Rezoning Transportation Analysis
Petition Number: Insert Zoning Petition #2021-161
General Location Identifier: 22902119

Revision Log:	Date	Description
	08-20-2021	First Review (WB)

Transportation Summary

**Rezoning Site Plan**

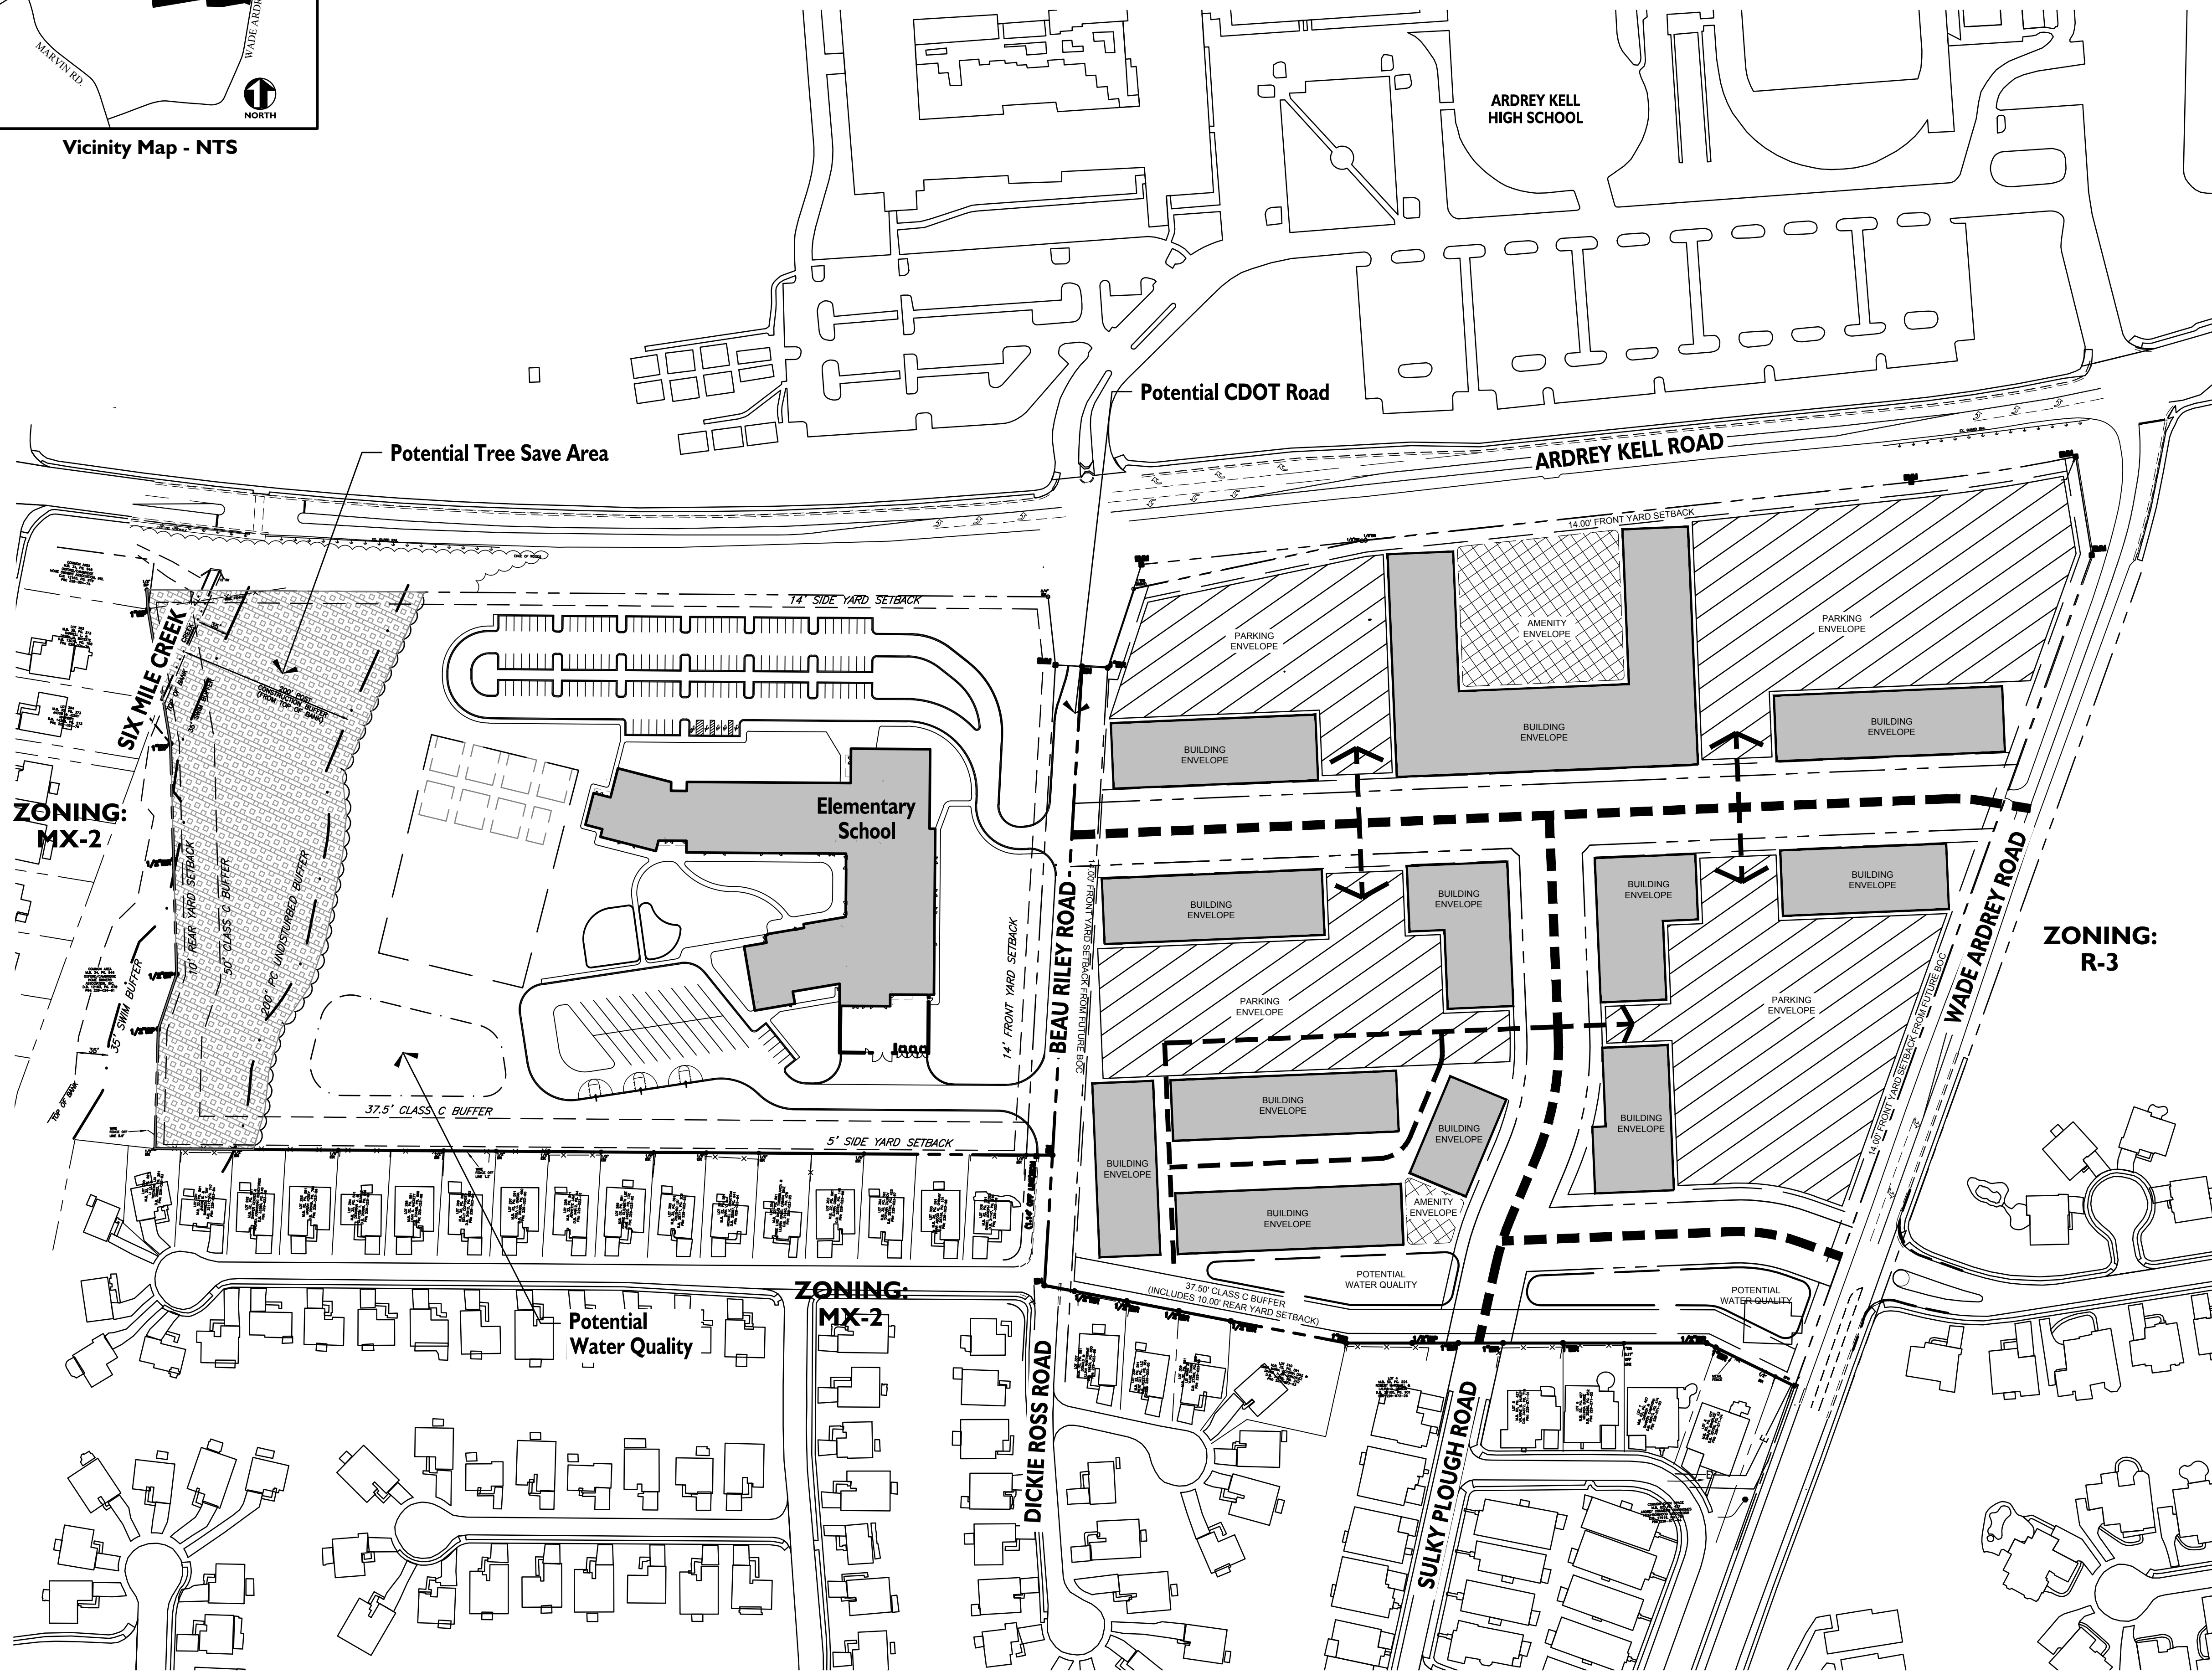
Label and dimension the curb and gutter from the centerline for each road on the site plan.

- 3. The proposed dwelling units exceeds 12 per acre. Per Chapter 20 Subdivision ordinance, site plan and conditional note(s) revisions are needed to commit to construct an 8-foot planting strip, and 8-foot sidewalk along Beau Riley Road. The wider sidewalk also meets the Charlotte WALKS Policy.

4. Site plan and conditional note(s) revisions are needed to commit to installing a 12' multi-use path with an 8' planting strip, along the site's Ardrey Kell Road Frontage to meet the Charlotte BIKES and Charlotte WALKS Policies.

5. Revise site plan and conditional note(s) to identify, depict, label, dimension, and itemize all proposed transportation-related infrastructure improvements. The conditional notes should include commitments to fully construct and fund all TIS-recommended and ordinance-required transportation improvements with applicable phasing and funding sources identified.
6. Add conditional note that all public transportation improvements will be constructed and funded by the residential development before the residential site's first building certificate of occupancy is issued.
